CITY OF ALBUQUERQUE

March 30, 2021

Re: **Dunkin Donut**
4201 Wyoming Blvd NE
Traffic Circulation Layout
Architect's Stamp 03-22-2021 (G19-D042)

**11 REGULATORY SIGNAGE**  
N.T.S. NOTE: ALL REGULATORY SIGNAGE SHALL BE INSTALLED IAW M.U.T.C.D.

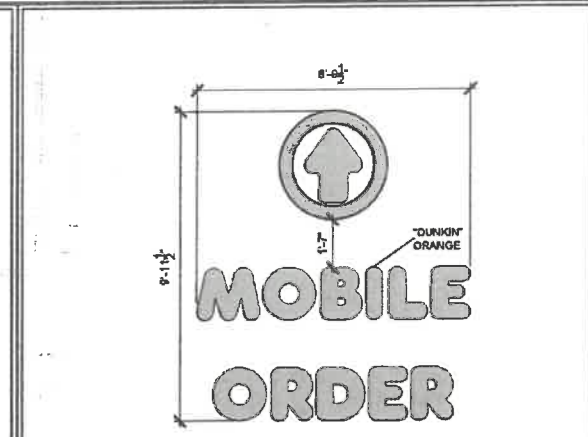
2. **Provide separate key notes for 'One Way' at the drive thru entrances. West side of entrance should be R6-2L and on the east side of entrance should be R6-2R.**

TCL-1.0

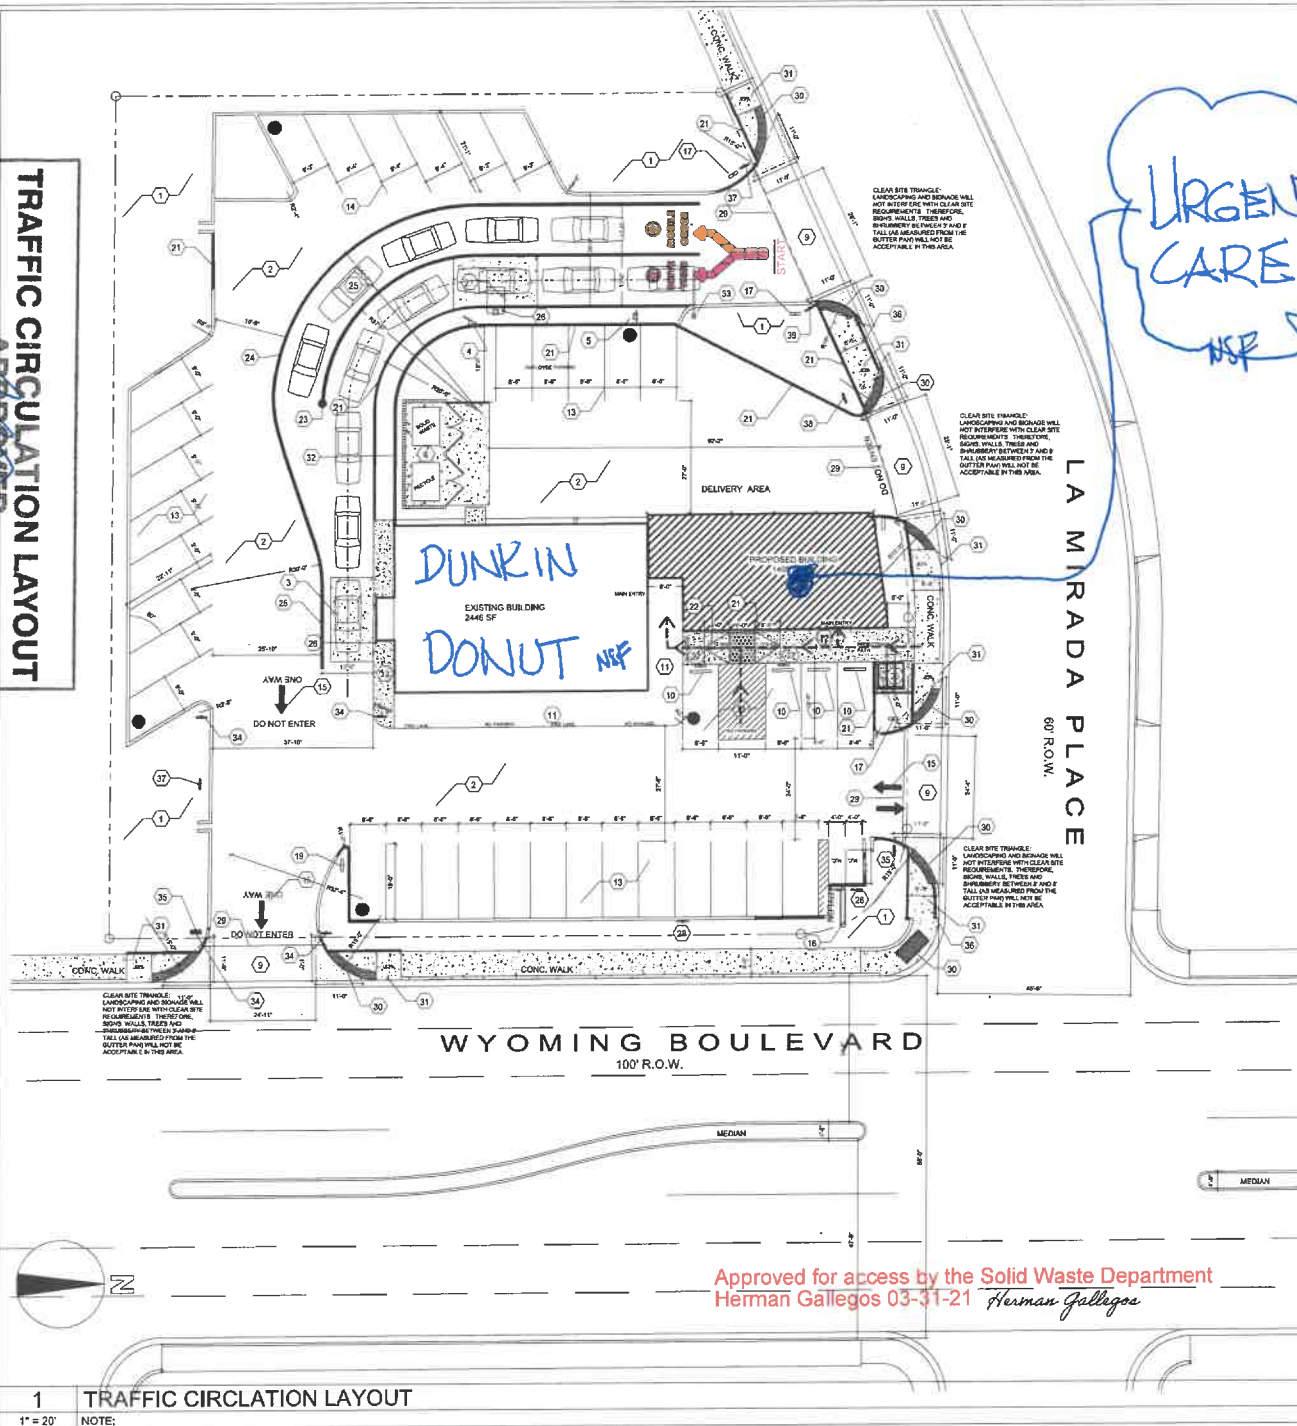
1. **List the number of parking spaces required by the IDO as well as the proposed number of parking spaces including bicycle and motorcycle parking and discuss with Zoning. Please break down the parking requirements for each proposed business. Otherwords Dunkin Donuts and Urgent Care should have its own required calculations.**
